RIBBLE VALLEY BOROUGH COUNCIL

Officer:	██████	Direct Tel:	██████████	Council Offices Church Walk Clitheroe Lancashire BB7 2RA
Email:	██			
Our Ref:	RV/2024/ENQ/00042			
Proposal:	Change of use from redundant barn to single dwelling.			
Location:	Lower Hud Lee Farm, Longridge Road, Hurst Green, BB7 9QP.			
Date of site visit	12/7/24			
Date:	9/8/24

Pre-Application Enquiry Response

PROPOSED ELEVATIONS

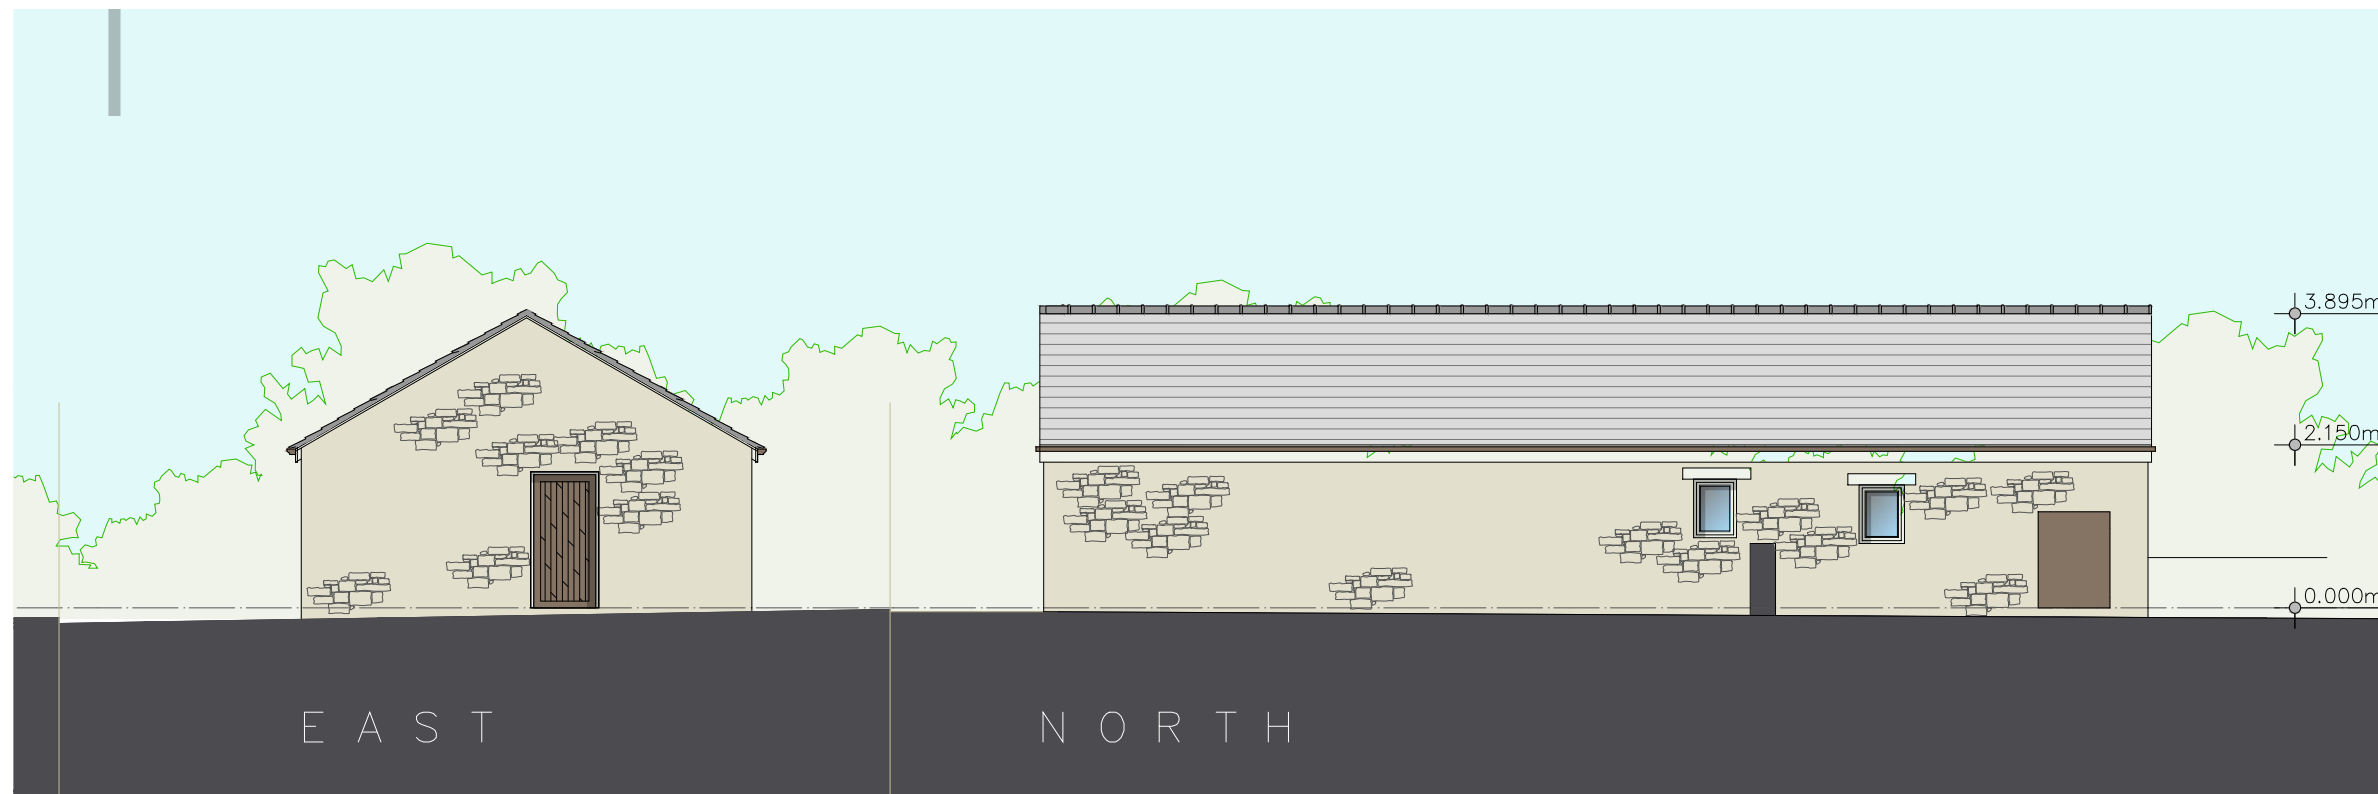
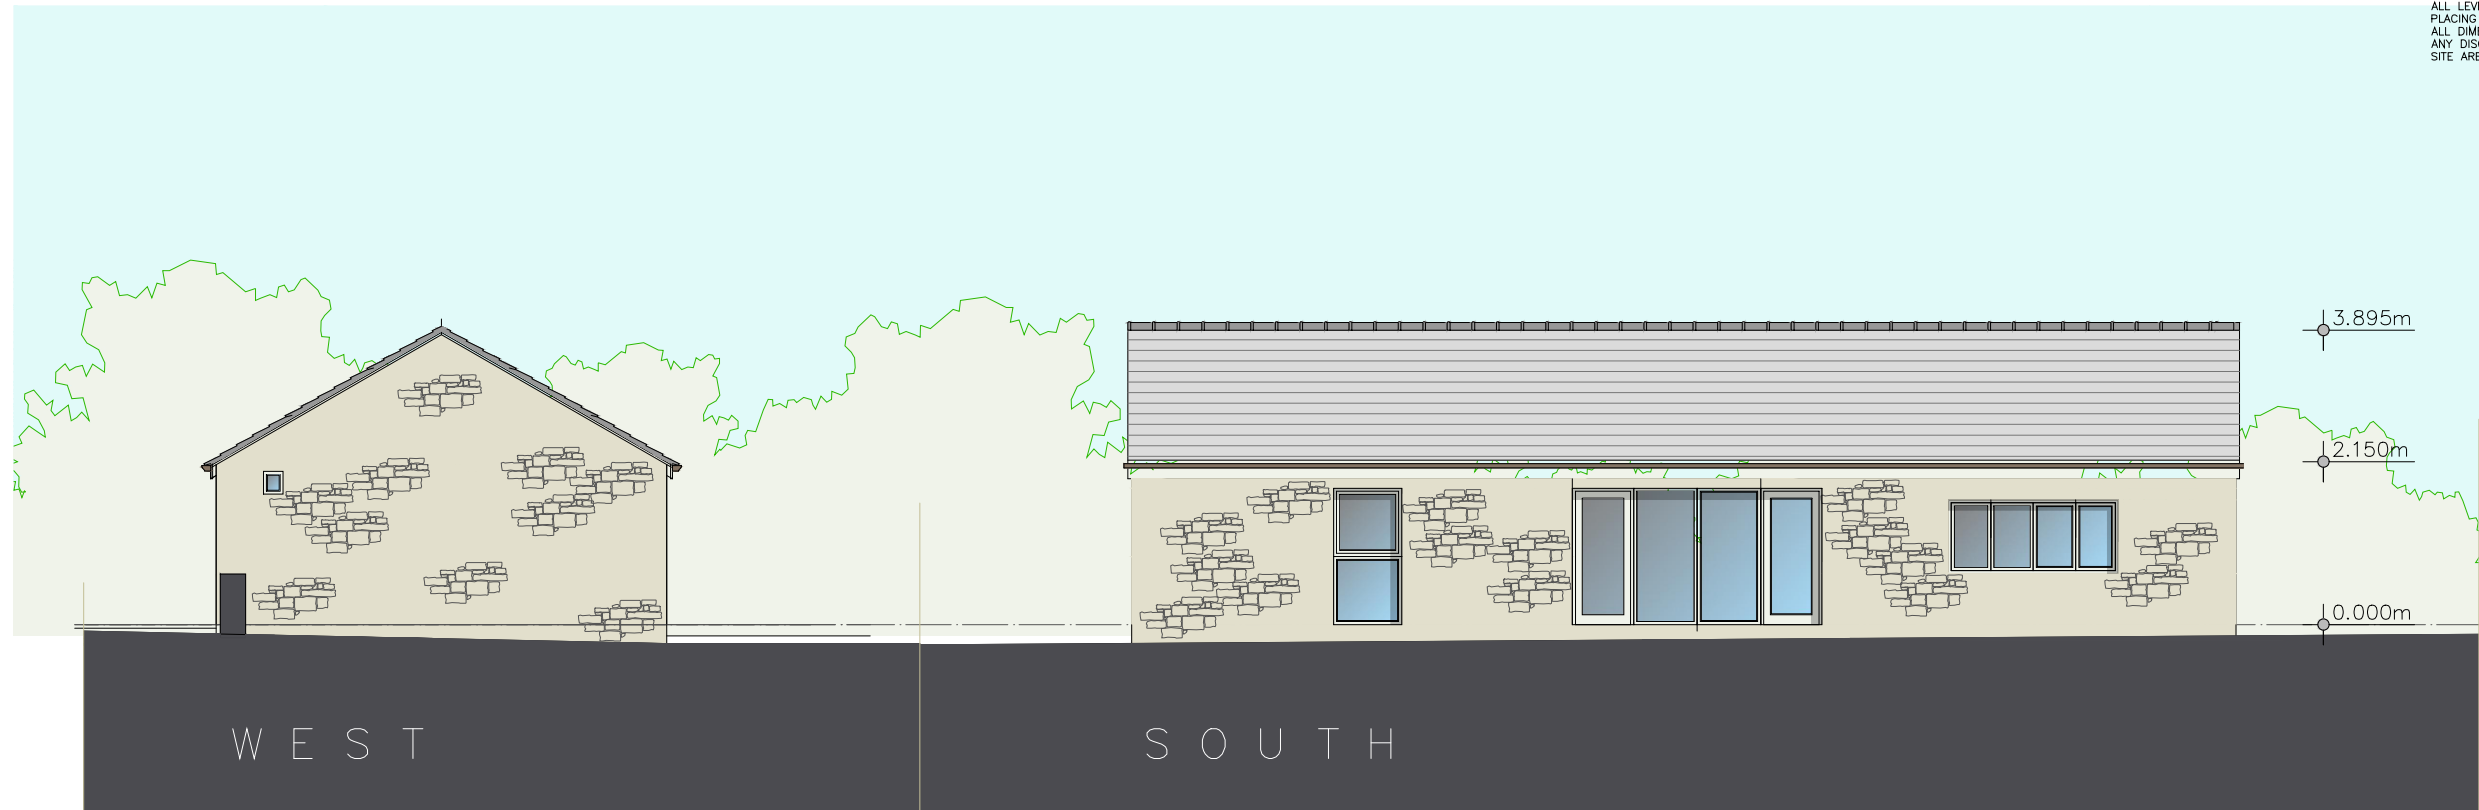
Having regard to criteria point 3, the building subject to the proposed conversion comprises random rubble stone elevations and a slated gable roof with the building occupying a rectangular footprint. Notwithstanding this, Google Street imagery from June 2022 shows the presence of an entirely different building (consisting of stone and brick with a partially intact mono pitched roof) in the same area occupied by the existing building. As such, the aforementioned historic imagery appears to indicate that the original building on site has been subject to substantial reconstruction (and possibly complete demolition). Unlike the previous building on site which appeared to be largely rustic in appearance, the existing building subject to this enquiry comprises a somewhat domestic appearance (more akin to a detached bungalow property) by virtue of its modern slated gable roof, sequence of openings (Southern elevation) and timber fascia boards. As such, the existing building on site is not considered to be wholly in keeping with the rural vernacular of the former agricultural building or vernacular of agricultural buildings within the locality. Furthermore, the insertion of glazing into the building's

Southern openings (which do not reflect the randomised sequence of openings typically seen on agricultural buildings), in conjunction with the length of the proposed access track (approx 30 - 40 metres in length), parking area and domestic curtilage and associated paraphernalia would collectively have an urbanising impact on the site, with this impact being discernible in the public realm from Public Right Of Way FP0303003. Furthermore, given that the original building on site appears to have been significantly altered (or possibly completely demolished) it is not possible to fully assess the impact of the works undertaken upon nature conservation interests (bats / barn owls / nesting birds). In light of the above, the proposal would therefore fail to satisfy the requirements of criteria point 3 of Policy DMH4.

Having regard to criteria point 5, and as previously conveyed, it is considered that the proposed development as a whole would have an urbanising impact on the site and as such would fail to satisfy criteria point 5 of Policy DMH4 and the requirements of Policy DMH3 with respect to design / visual impact.

PROPOSED SKETCH PLANS

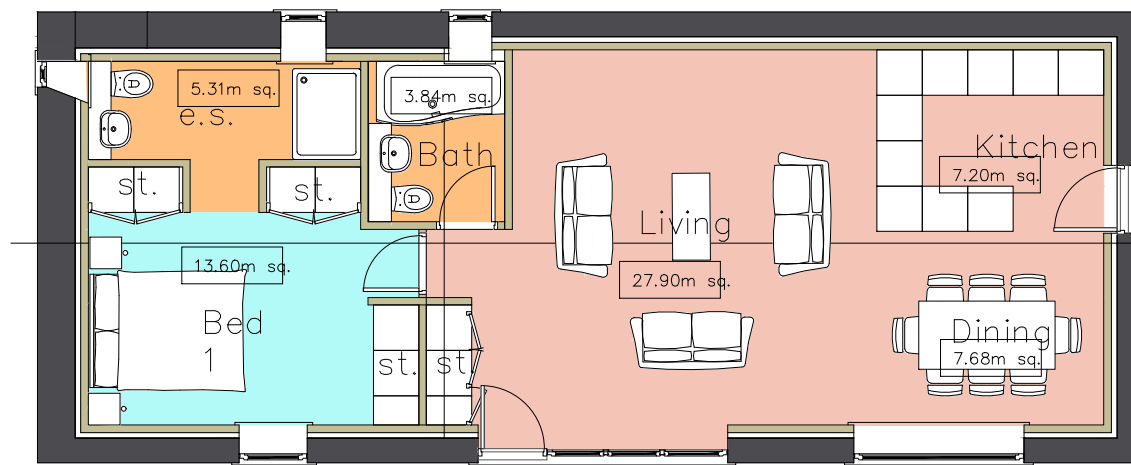
In respect to criteria point 2, access to the barn would be shared with the existing shared access which serves Lower Hud Lee Farm and Adamson House. The barn is currently accessed through a field access / grassed area therefore there would be a requirement to install an additional access track to the barn (approximately 30 metres in length) however construction of this would be at the applicant's own cost. It is further understood that foul water would be dealt with via a package treatment plant, the installation of which would also be at the expense of the applicant. Accordingly, it is not anticipated that the proposal would result in the provision of any unnecessary expenditure by public authorities and utilities on the provision of infrastructure.
